Rezoning Transportation Analysis
Petition Number: Insert Zoning Petition #2021-195
General Location Identifier: 20105108, 20105106

Revision Log:

| Date | Description |
|------------|--------------------|
| 02-21-2022 | Third Review (KP) |

The petition is located adjacent to Arrowood Road, a State-maintained major thoroughfare and Interstate 485, a State-maintained freeway. The petition is location within the limits of the Steele Creek Area plan and is located outside Route 4. The petition is a site plan amendment to the previously approved rezoning 2018-121.

RZ-1

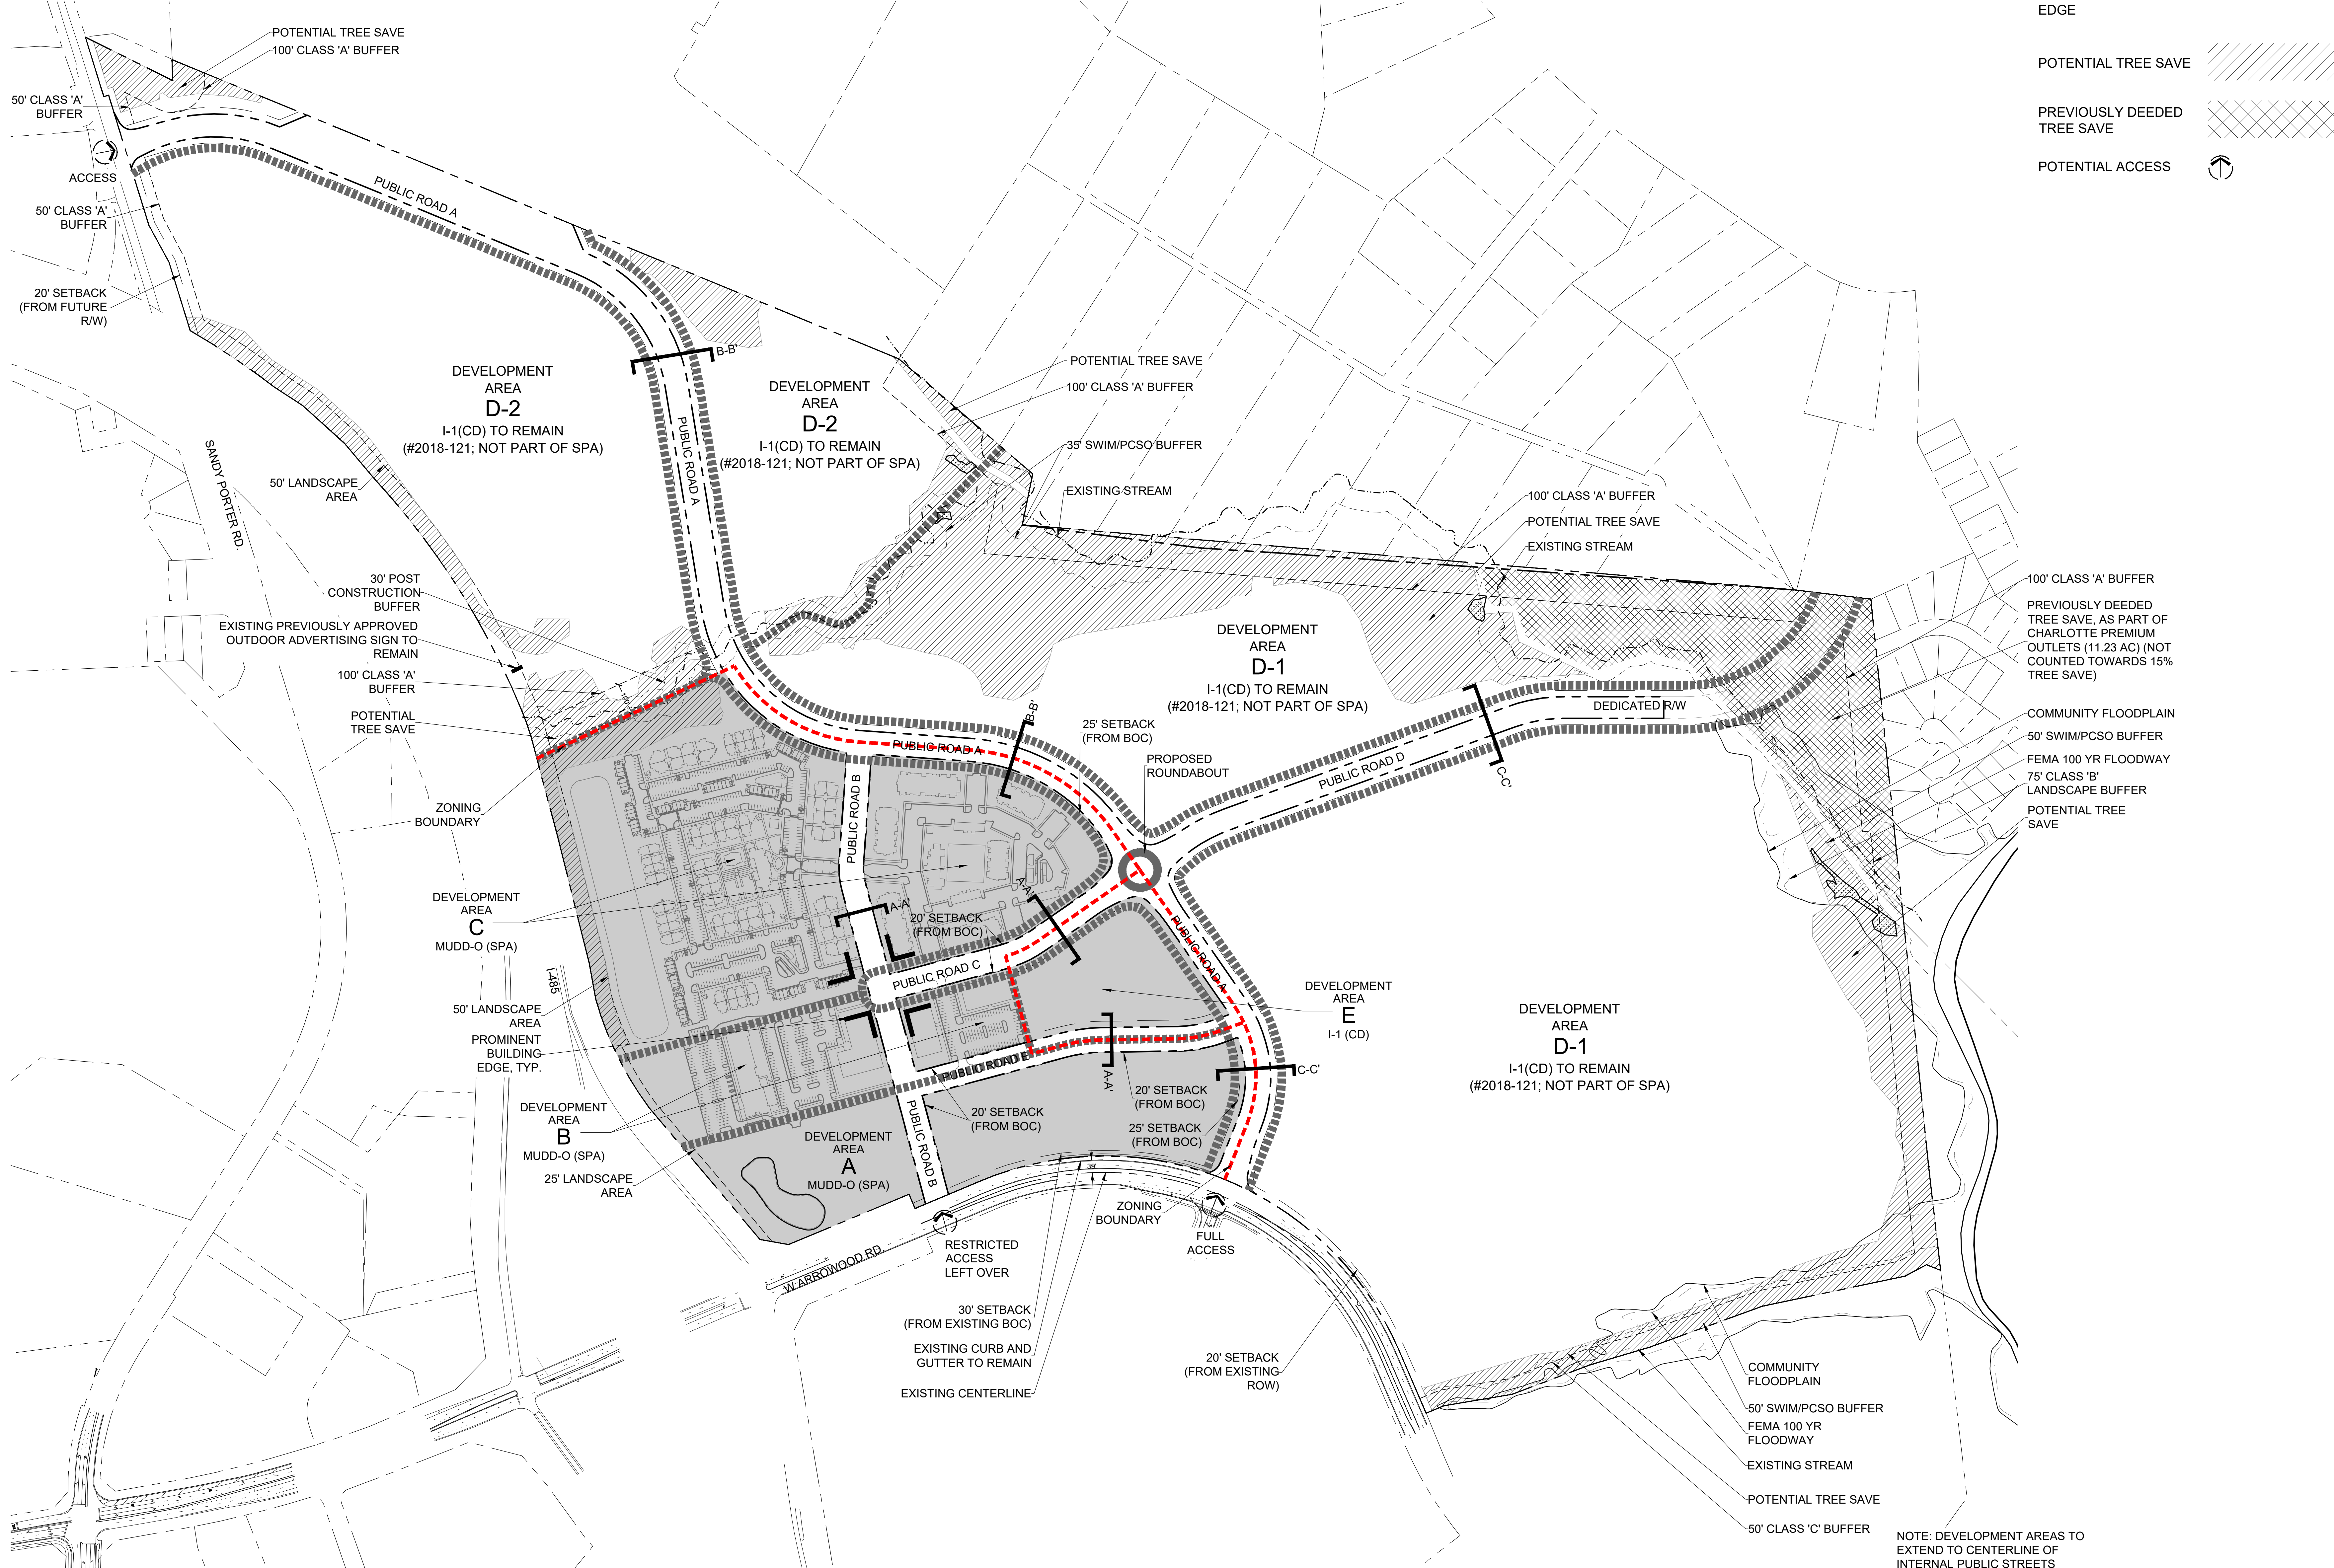
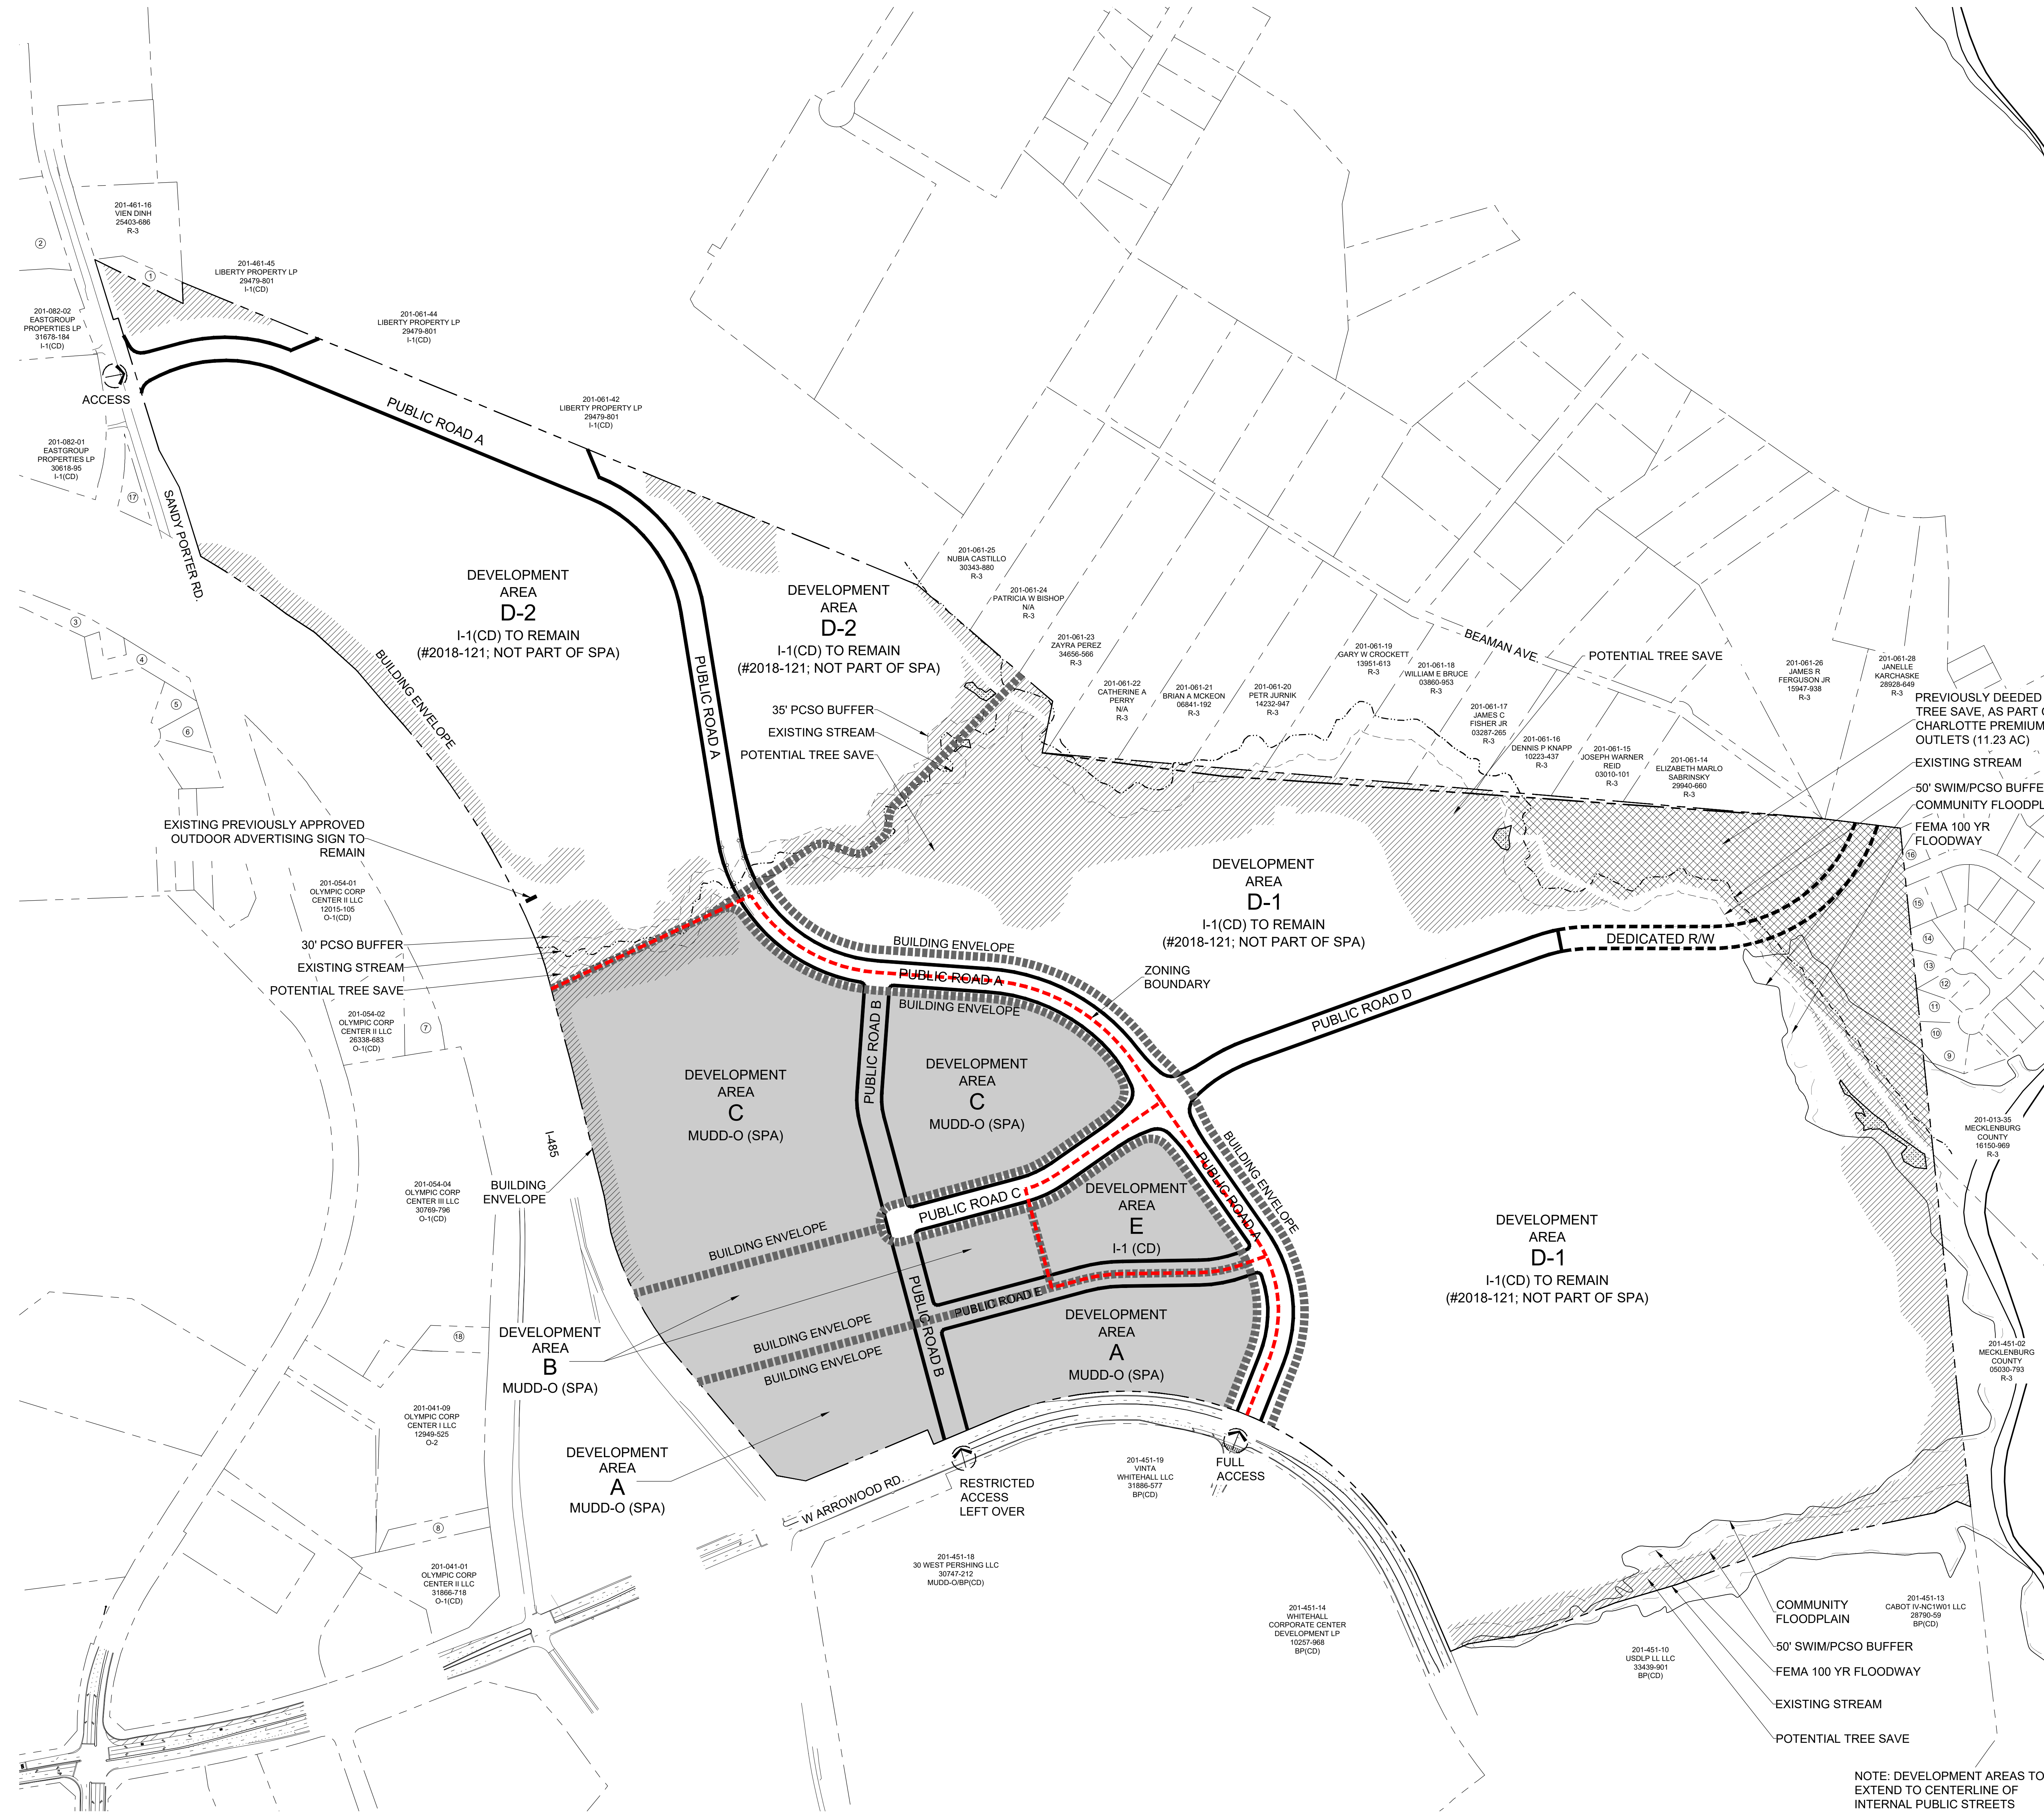
1. ~~**Outstanding Comment from 12-28-2021: Curb line:** The proposed zoning district has a setback measured from back of the existing or proposed future curb line.
 - a. ~~**Arrowwood Road:** The future location of curb and gutter is in the existing location~~

Label and dimension the curb and gutter from the centerline for each road on the site plan.~~

4. **Outstanding Comment from 12-28-2021:** Revise site plan and conditional note(s) to commit to constructing an 8-foot planting strip and 12-foot multi-use path along Sandy Porter Road per the pervious approved rezoning. The previous note show below should be used.

5. **Outstanding Comment from 12-28-2021:** Revise site plan and conditional note(s) to restrict Public Road E access at Public Road A to right-in / right-out if the required minimum intersection sight distance cannot be achieved.

6. **Outstanding Comment from 12-28-2021:** Add conditional note committing to the dedication of right-of-way to allow for the extension of Public Road D to the property line.
